Consultation Response from: KC Environmental Health (Pollution & Noise Control)

2024/90421 Helme Edge Farm, 31, Crosland Edge, Meltham, Holmfirth, HD9 5RS

Erection of single storey ancillary store/office accommodation/tool shed/toilet/kitchen facilities/tasting room

Date Responded:
5th April 2024

DRAINAGE SITE PLAN  
 AS PROPOSED  
 0 1000 2000 3000 4000 5000mm  
 SCALE 1:100

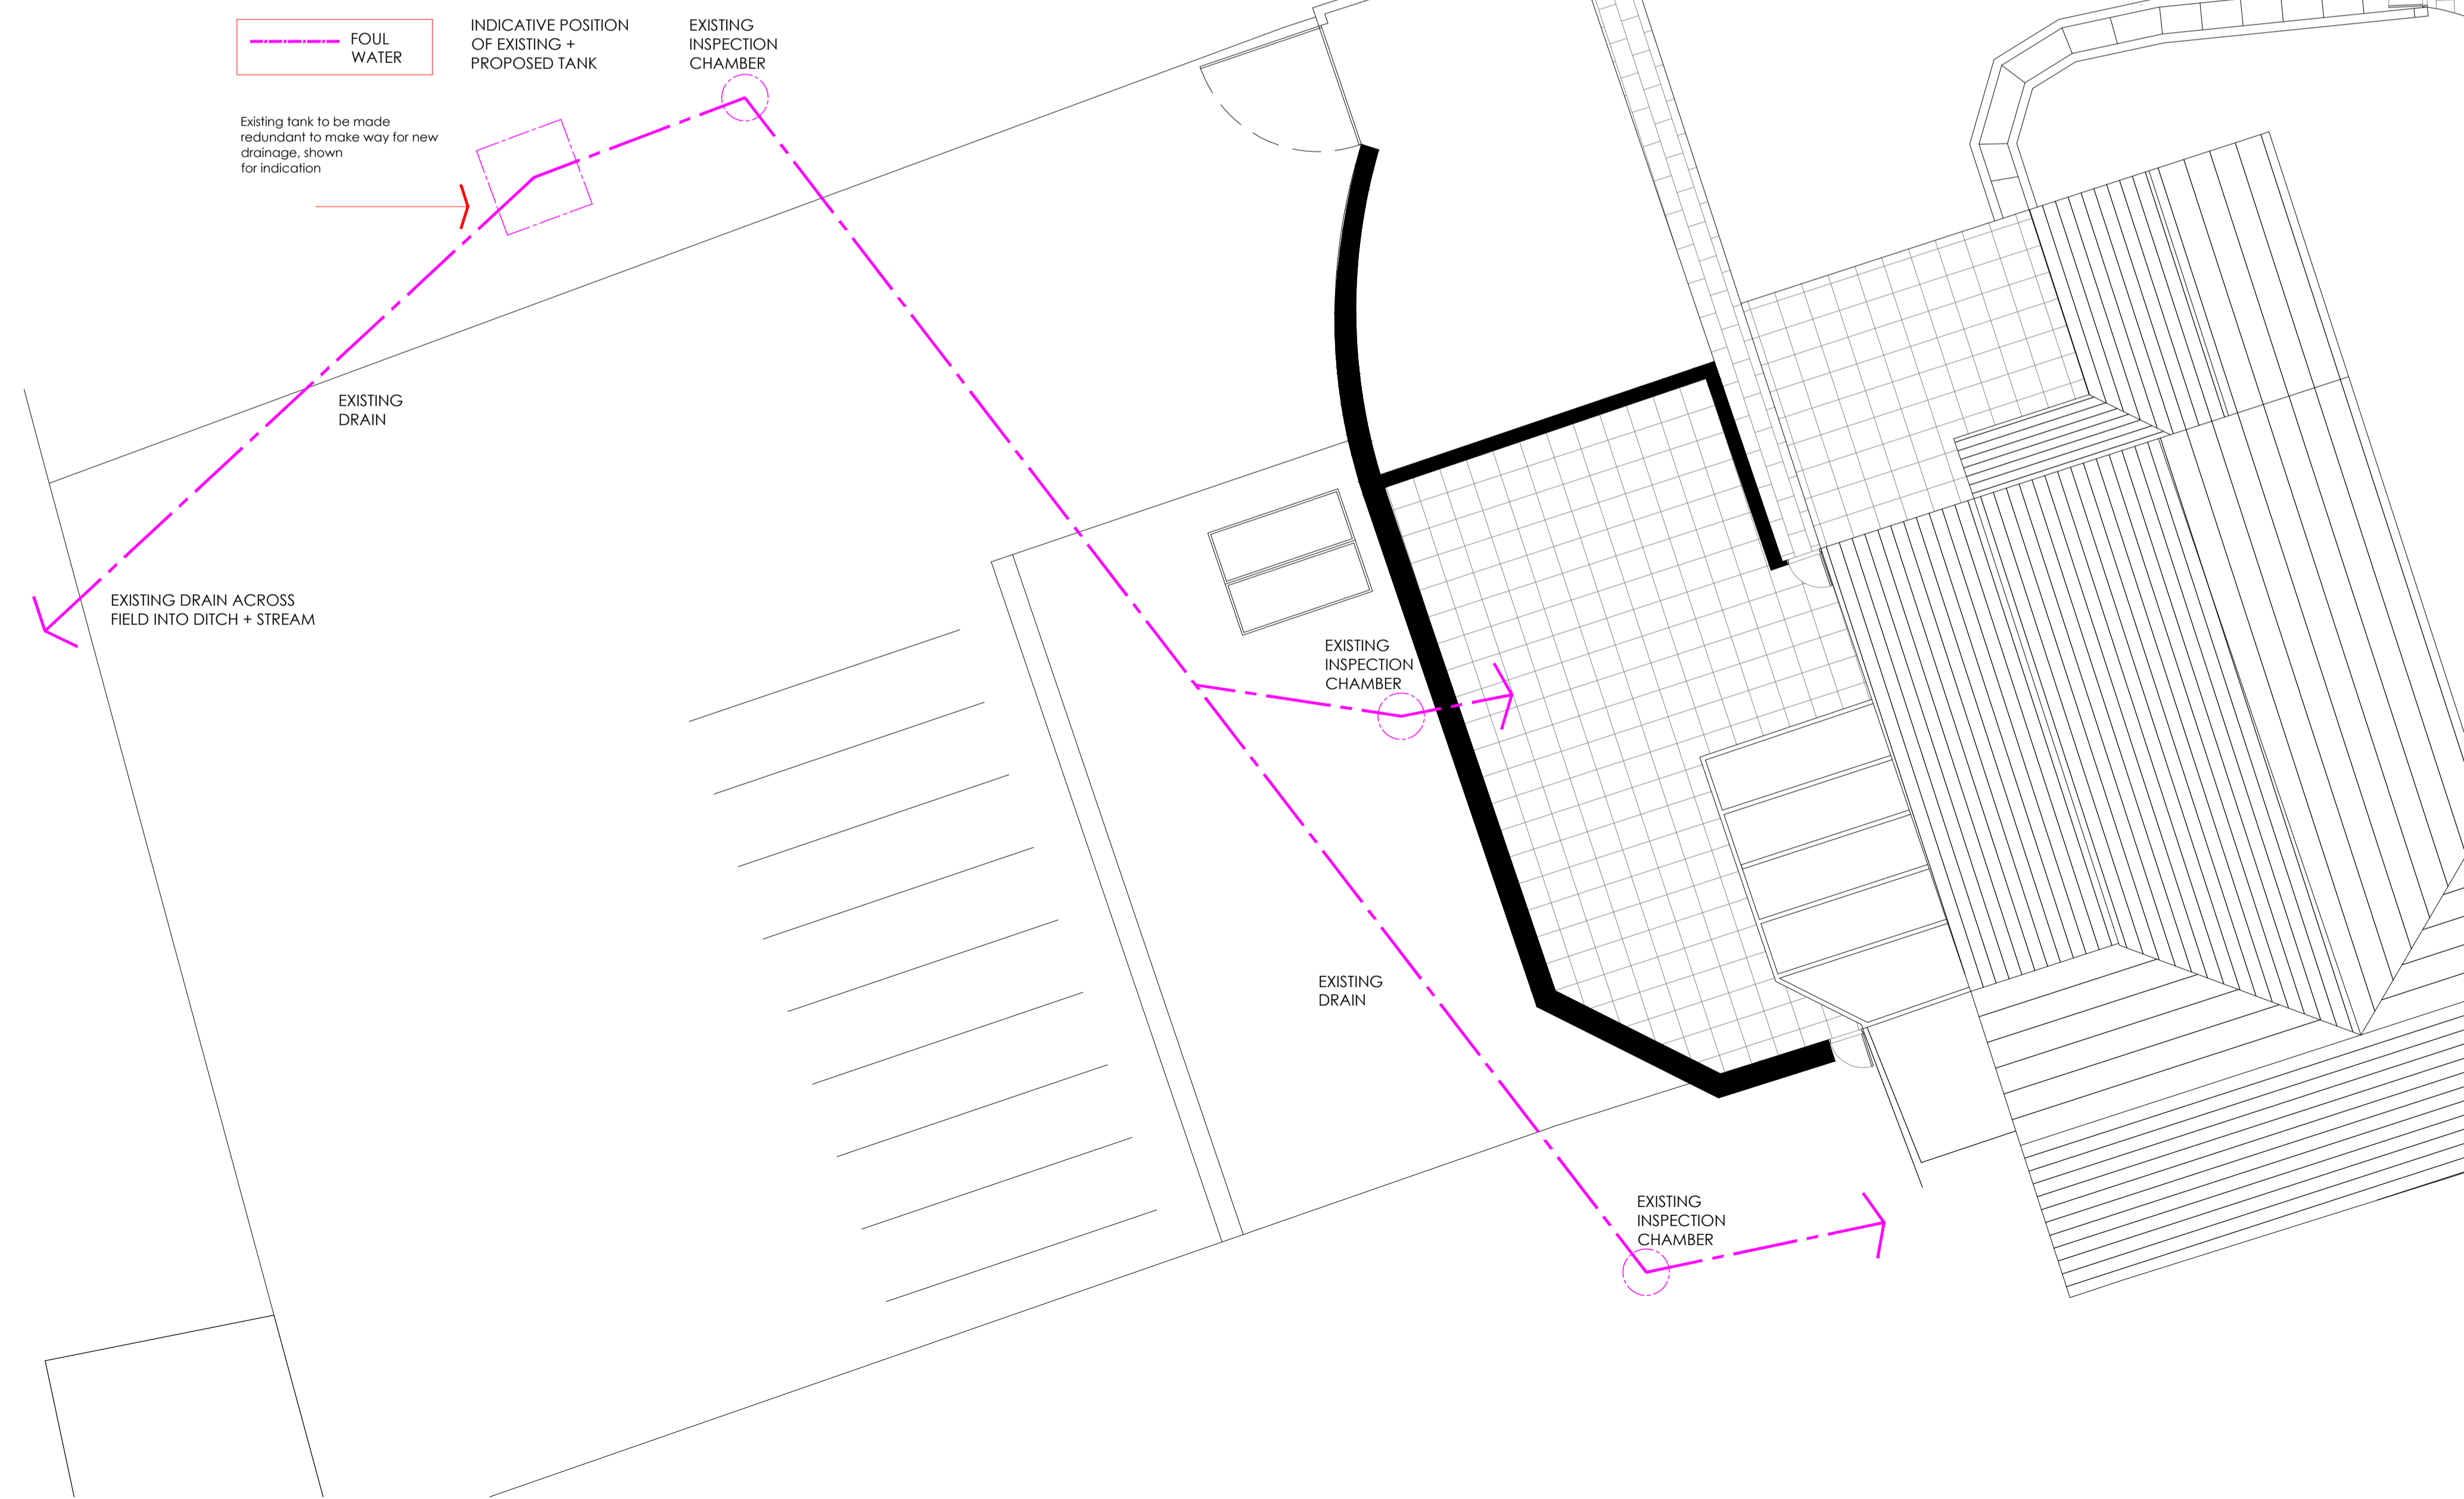
We understand from the supporting information that the intention is to connect into the existing foul water treatment system. However, no detailed information has been provided regarding this and we have concerns that it has sufficient capacity to cope with the additional volume of foul water that the proposed development will create.

To avoid the possible need for a further planning application relating to the construction of a foul drainage system, it is recommended that **before determining the application**, the applicant provides detailed information to show how a satisfactory foul drainage system is to be provided for the proposed development. The details must therefore include the following information:

- a) The location of the tank (which must not be so near to any inhabited building as to be liable to become a danger to health or a source of nuisance (a minimum of 7m is required but over 20m and down slope is preferable) or in an area where there is a risk of flooding). The discharge details for the tank must not present any risk of contamination to any watercourse, underground water or drinking water supply.
- b) Demonstrate that the tank will be of adequate capacity for the highest number of persons that may use the tank, and ensure it is in good working condition.
